From: Bloomer, David <David.Bloomer@lancashire.gov.uk>
Sent: 11 December 2015 12:22
To: Adam Birkett
Cc: LHS Customer Service; planning
Subject: app3/2015/0972 Haydock Nursing Home

Dave Bloomer
Highways Development Control
Lancashire County Council

SITE AREA PLAN (PROPOSED)

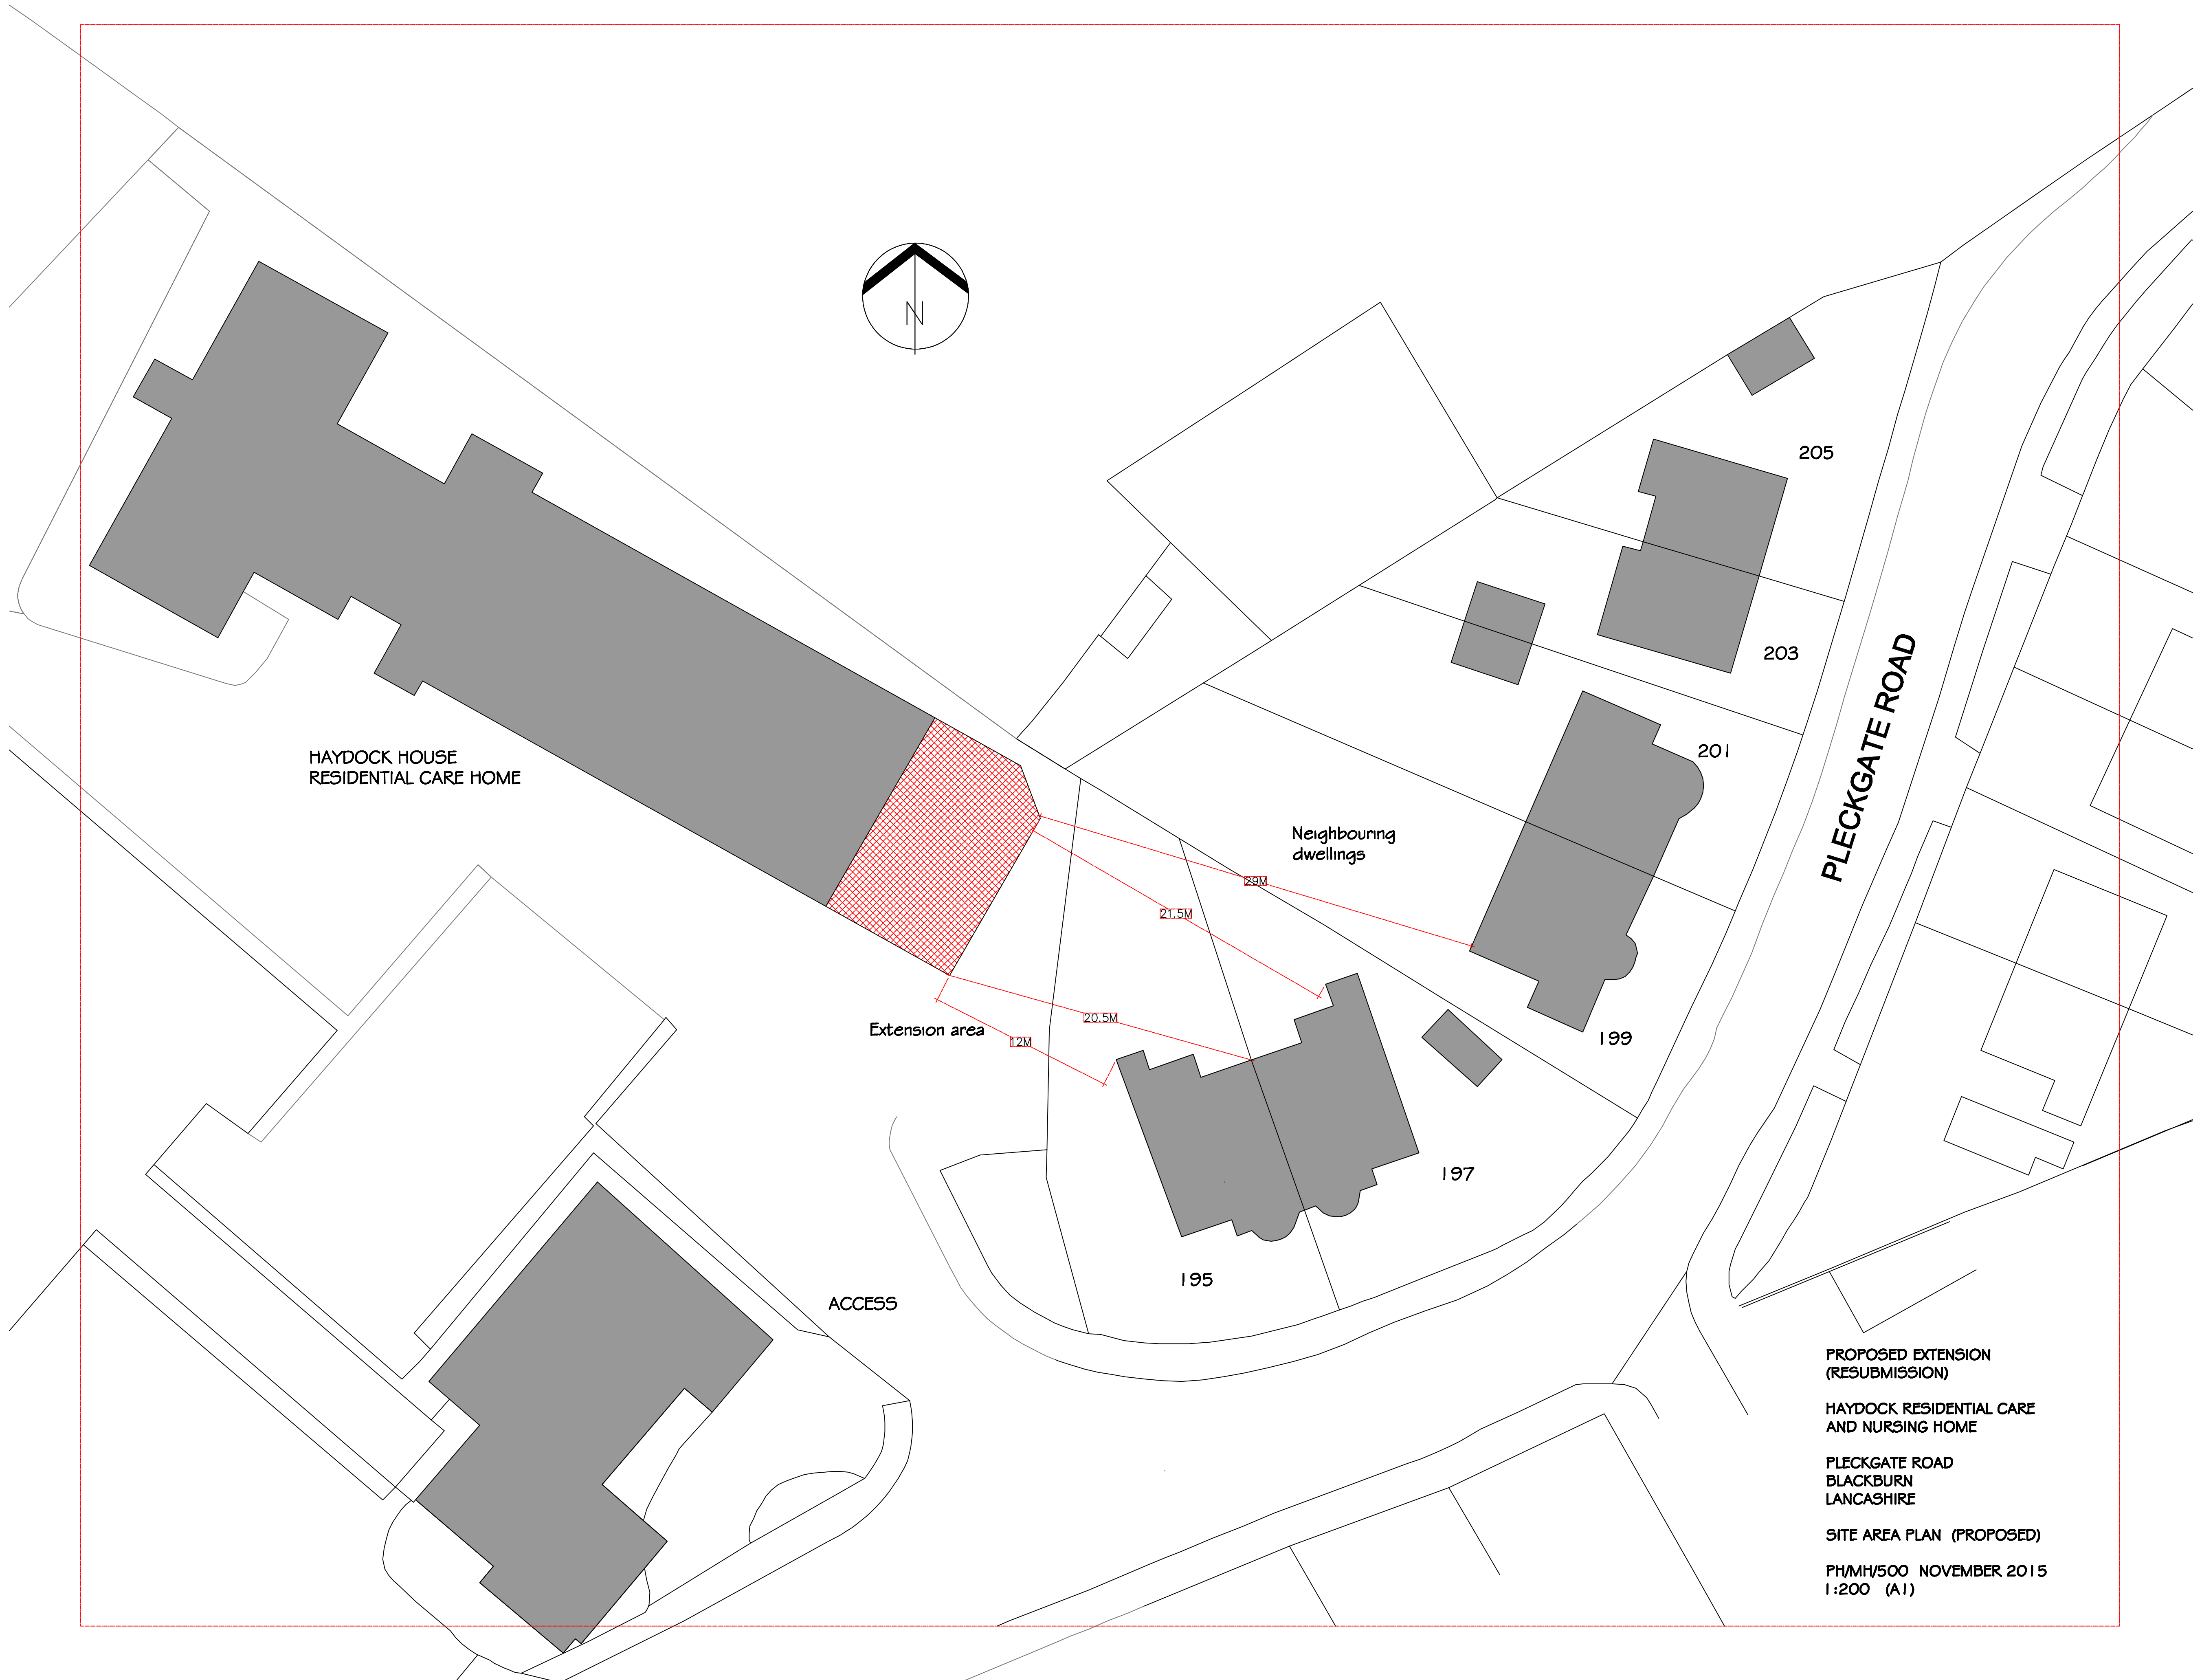
The proposal whilst satisfying the parking requirements for the care home would appear to be relying on the rearrangement of the parking provision for the industrial units opposite. Would it be possible to ask for a land ownership plan to determine if this is the case. I am mindful that the granting of planning permission may result in the proposed parking provision being undeliverable or may adversely affect access to the industrial premises and farm further into the industrial estate.
